2 Storey side & rear extensions with balconies, conversion of roof void to create En-suite Bedrooms including the insertion of 3no. new dormers, roof alterations, new Garage outbuilding with ancillary accommodation & link to main house & swimming pool.

Russet House Gorse Avenue Kingston Gorse Kingston

Thank you for your internet representation made on 11th June 2015 which has been recorded as '**an objection**' with the comments as follows:

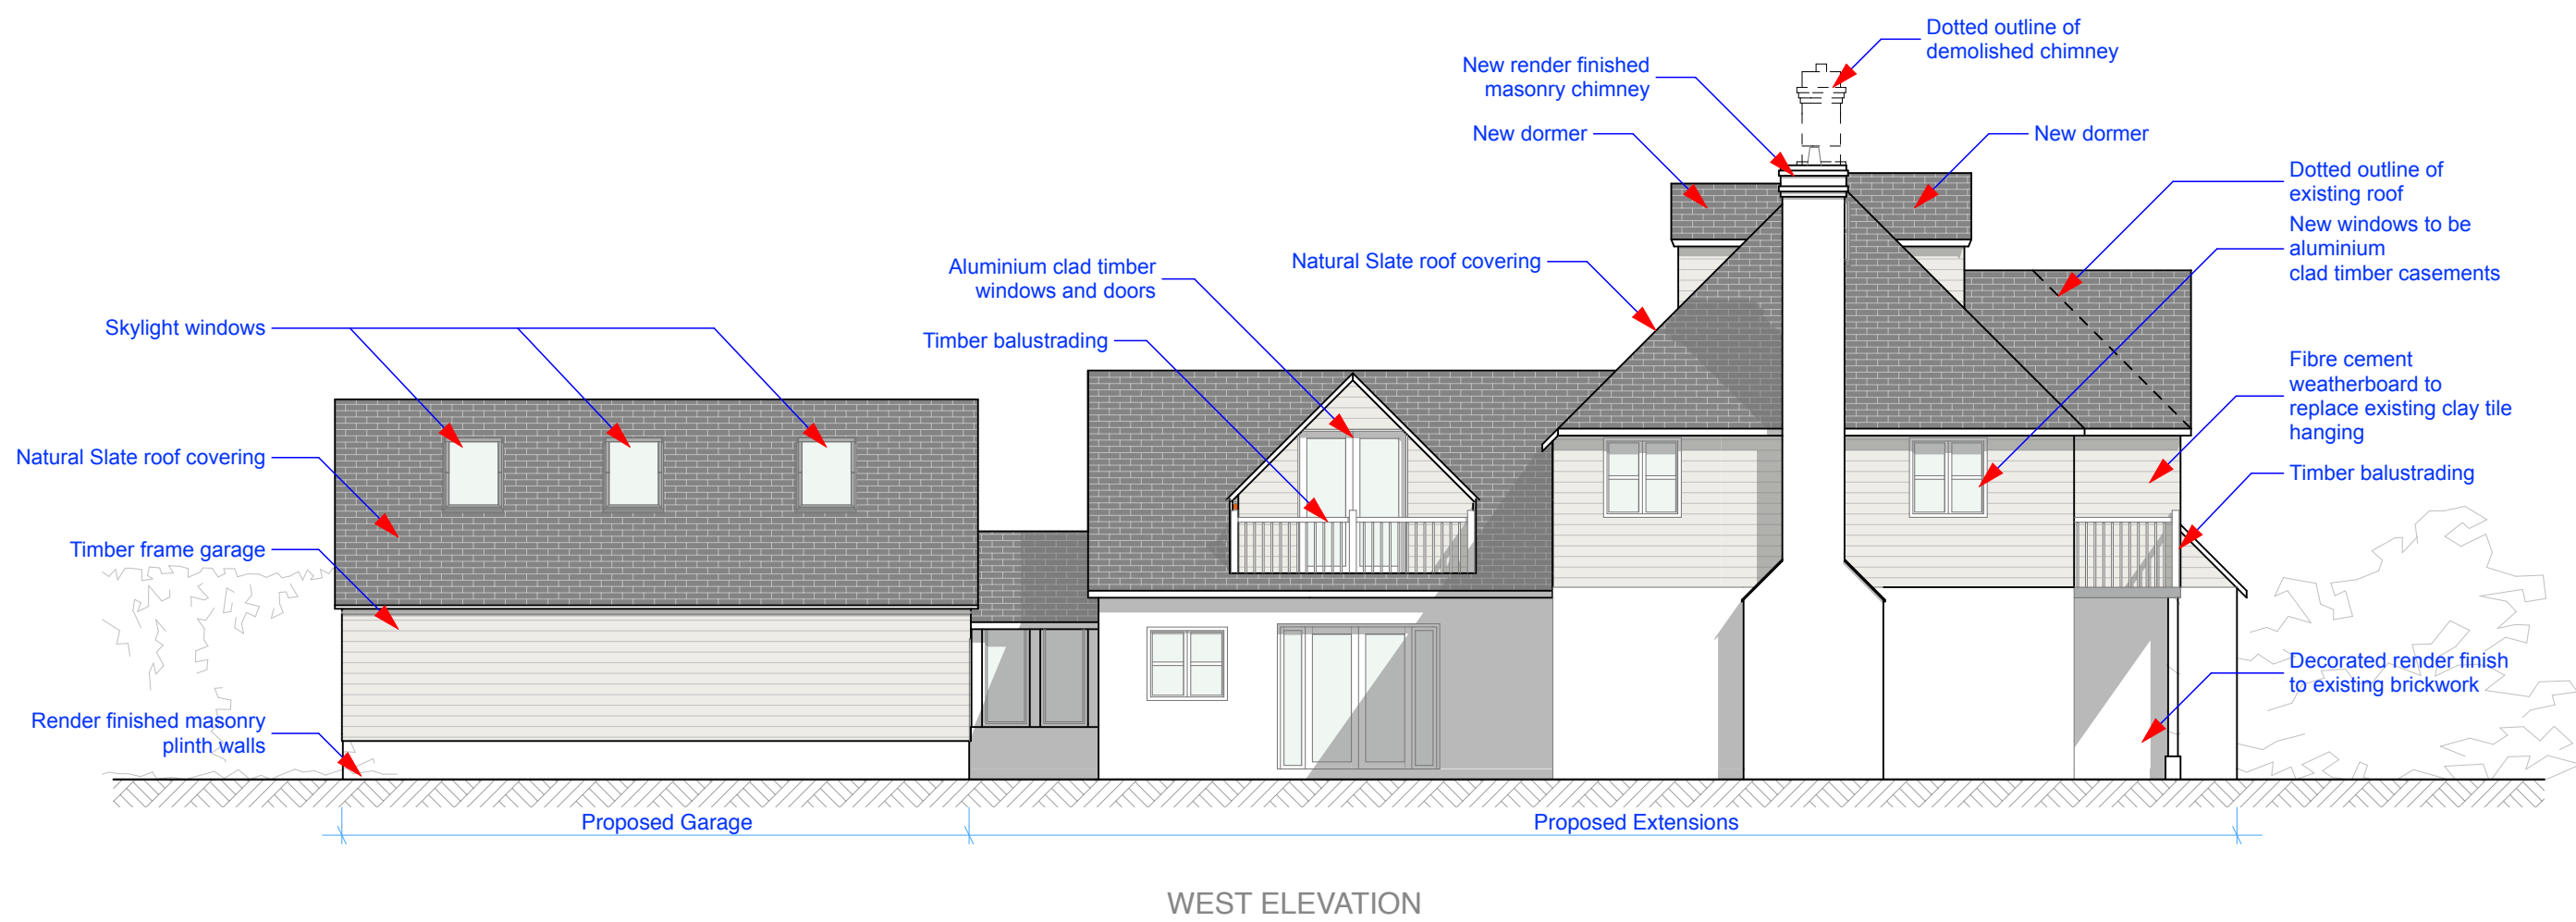
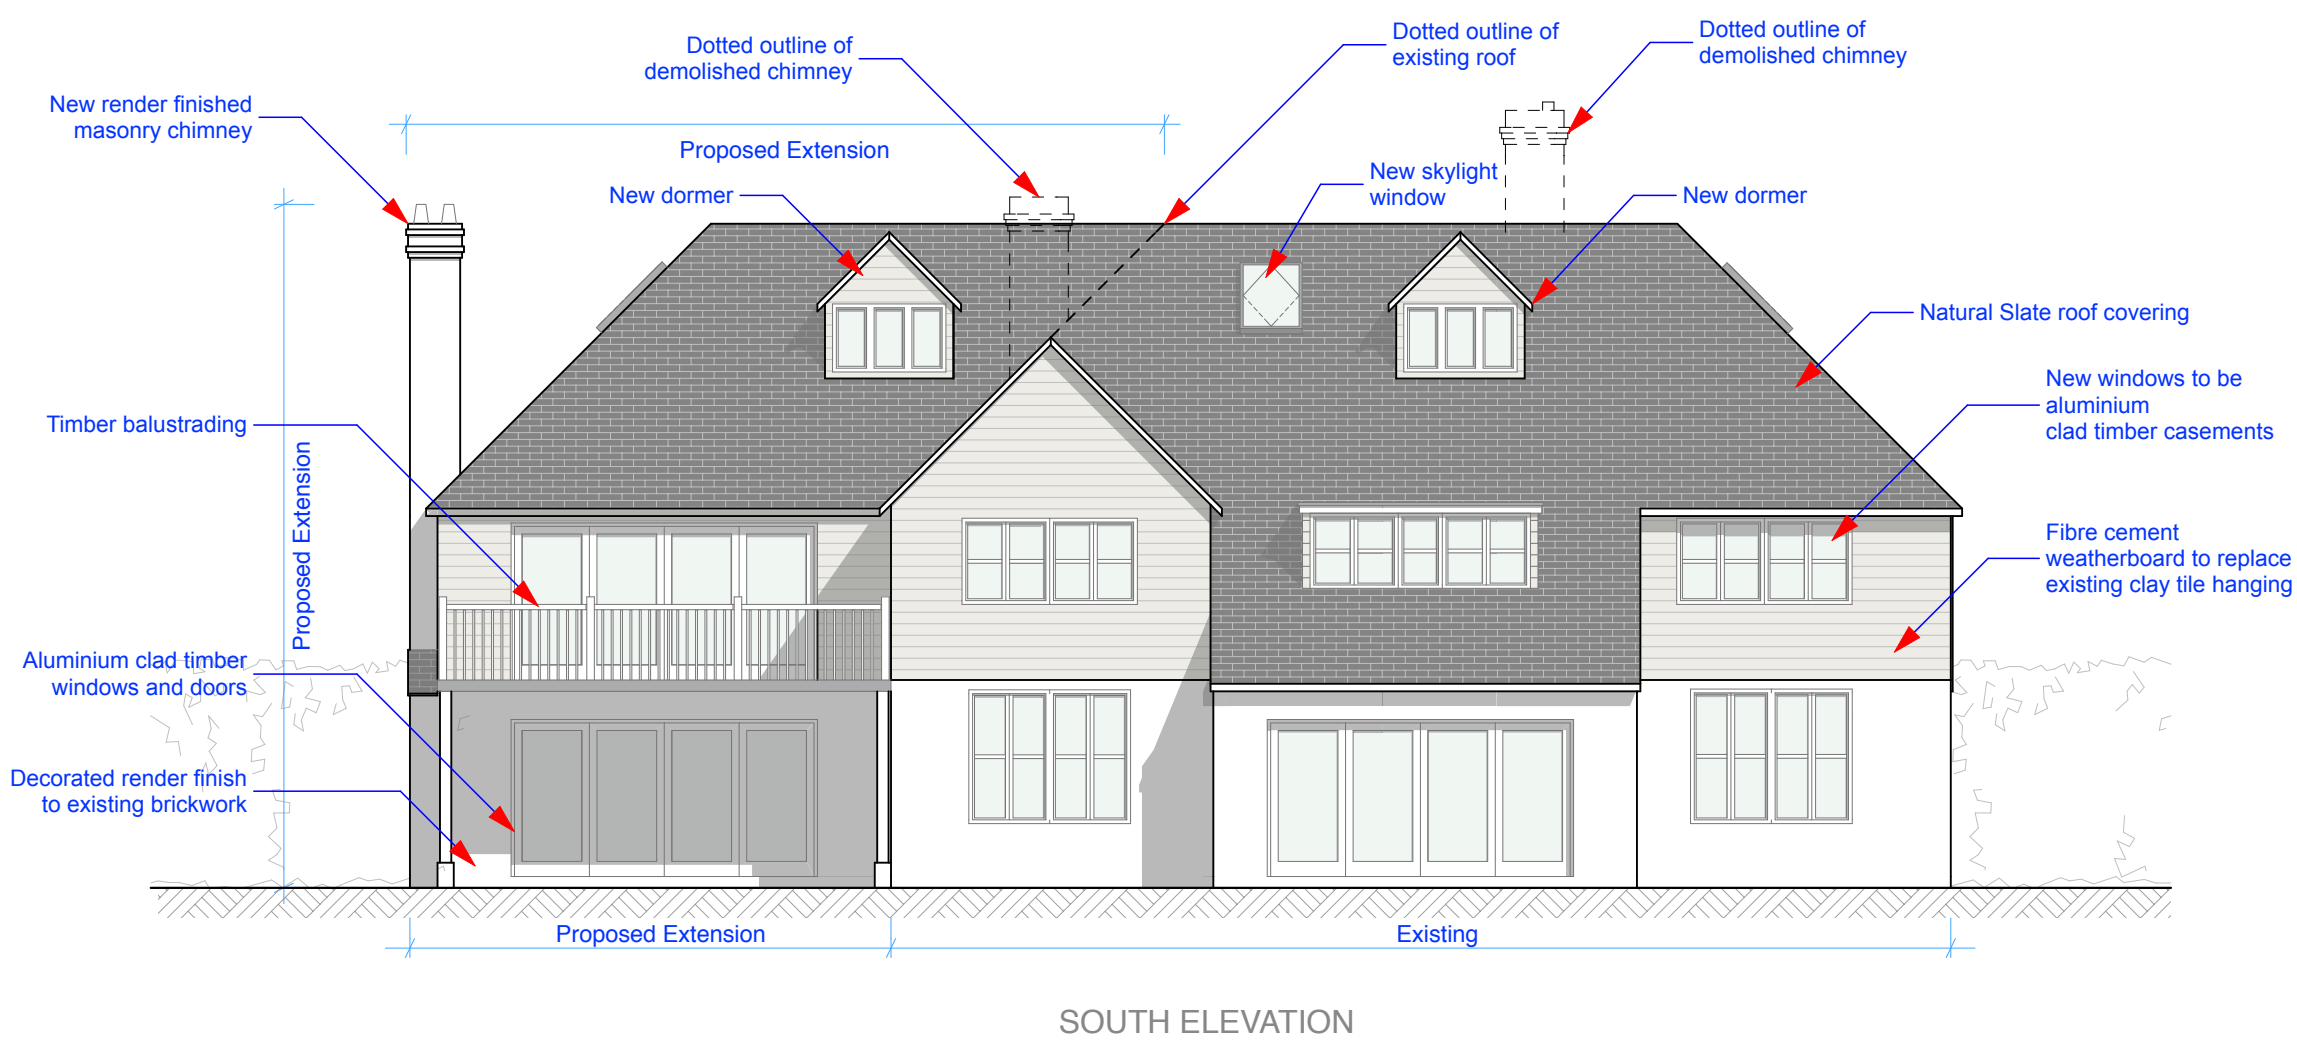
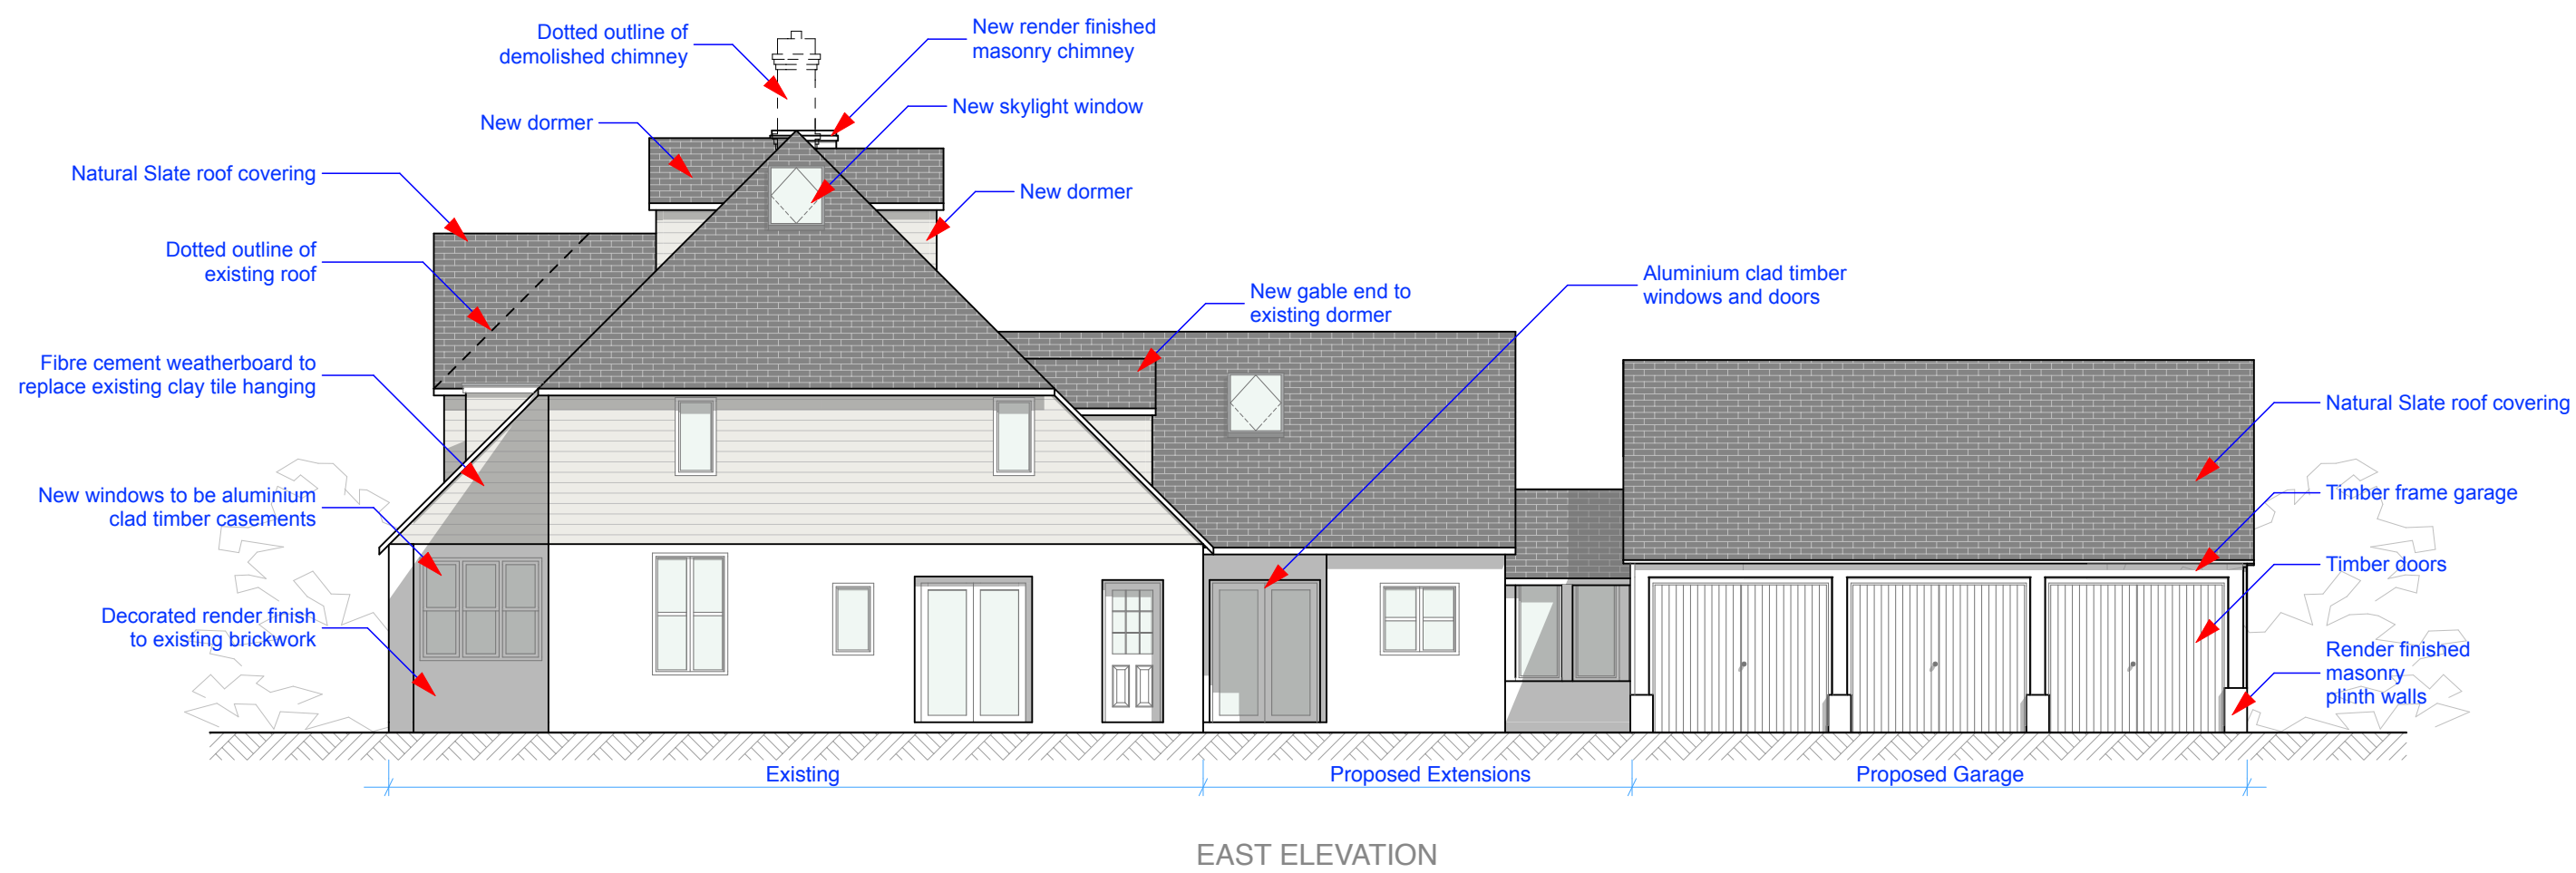
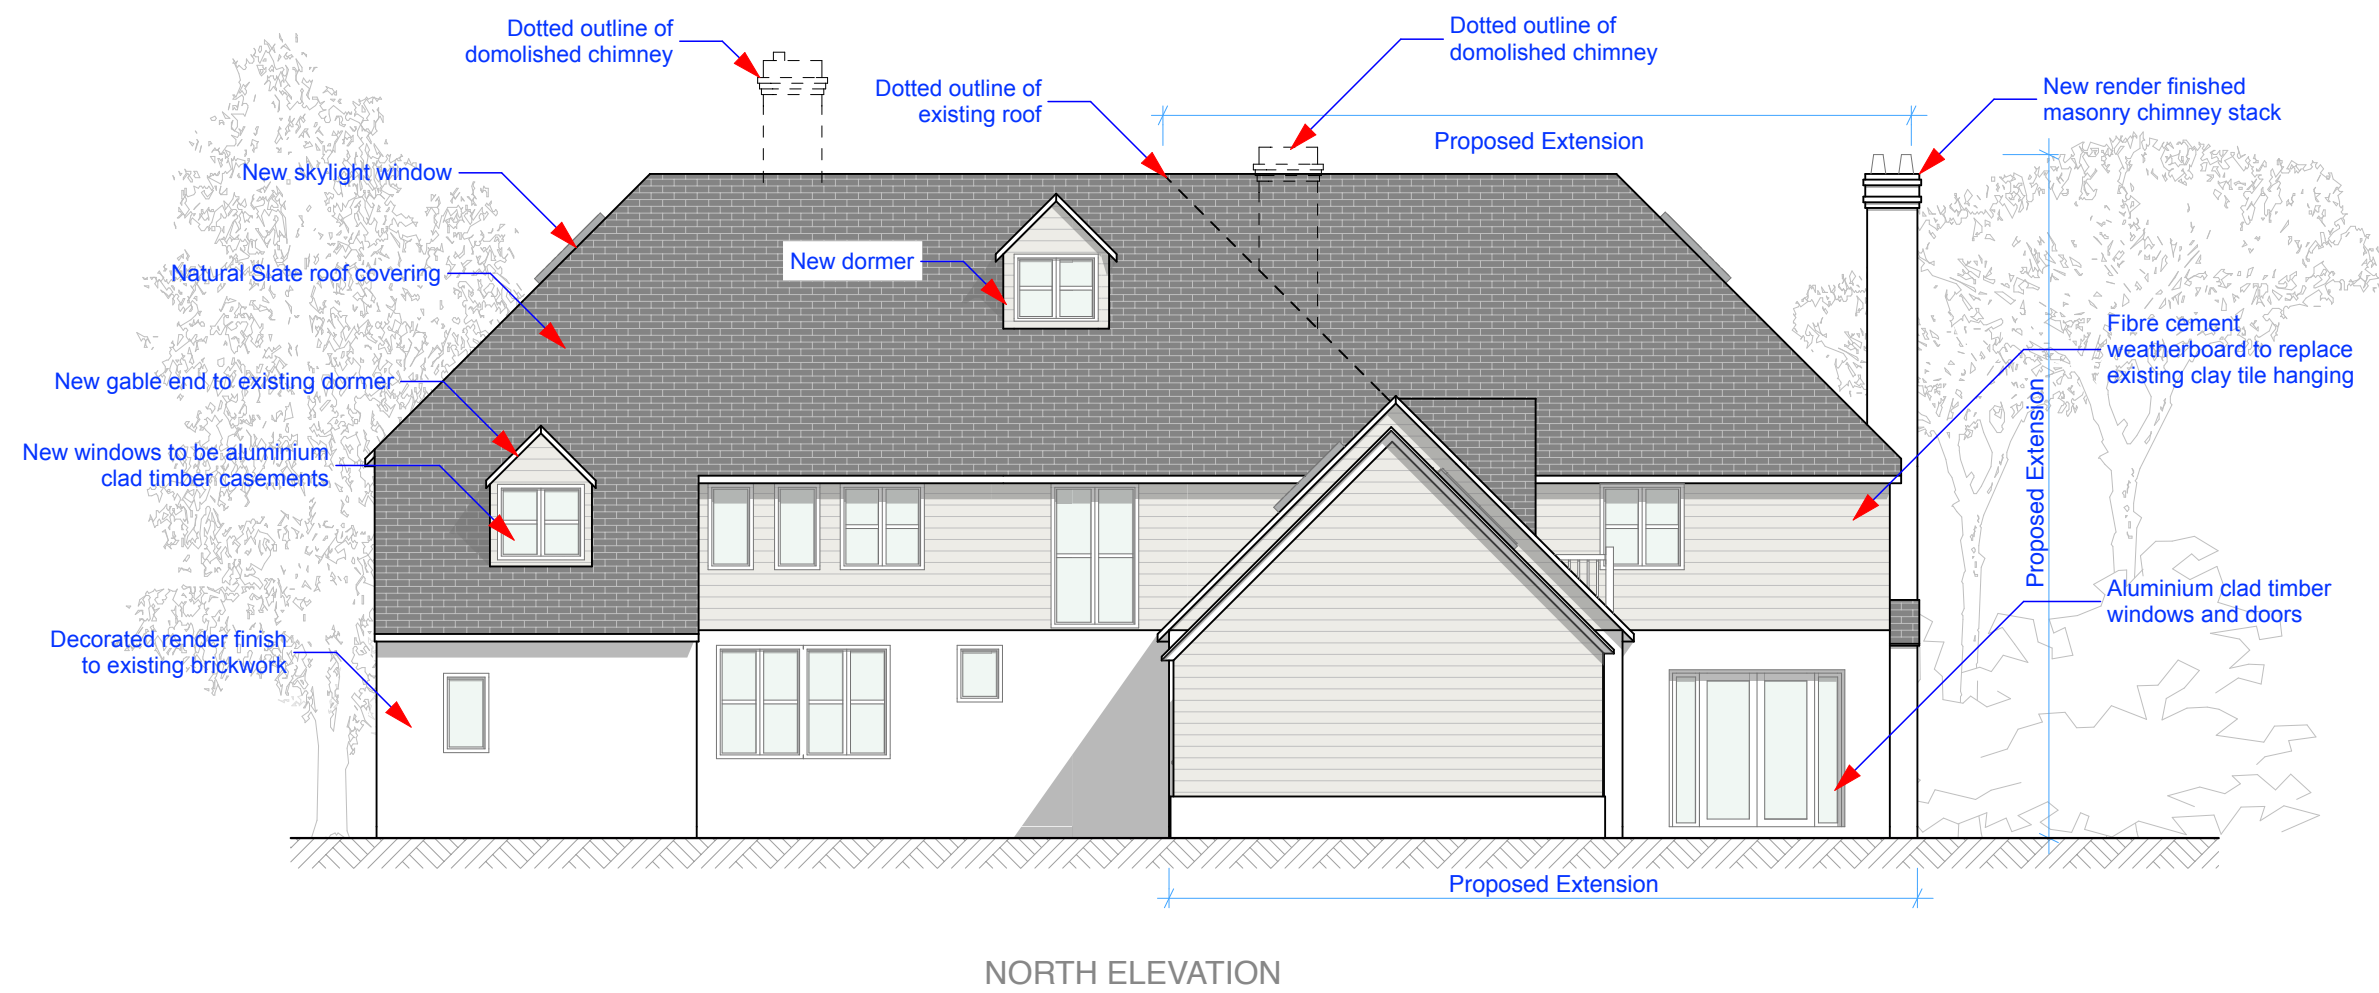
The Society does not object to the proposed extensions to Russet House. But it does consider that the proposed alterations to the cladding and roofing materials, and to the windows, are contrary to the policies of the Kingston Neighbourhood Plan. They would produce a house that was very different in character from the existing building and from the historic style of the Kingston Gorse Estate. Fibre cement weatherboard, proposed as facing material for the upper elevations, is a novel material for the area and would transform the appearance of the house. So would the replacement of clay tiles by slates on the roof, and the replacement of metal Crittall windows by aluminium faced timber windows

The Kingston Neighbourhood Plan states in Policy 7.1.i. that the design of new developments should be appropriate and sympathetic to the Parish's character and appearance in terms of materials (colour, texture) ... and in Policy 7.2.iii. it states that if alterations do not retain and enhance the condition and character of the existing building, the proposals must use materials which reflect the present character of the building.

To conform to these policies of the Neighbourhood Plan, the facing and roofing materials and windows of the altered house should resemble those of the existing house. The proposed materials do not reflect the current character of the building.
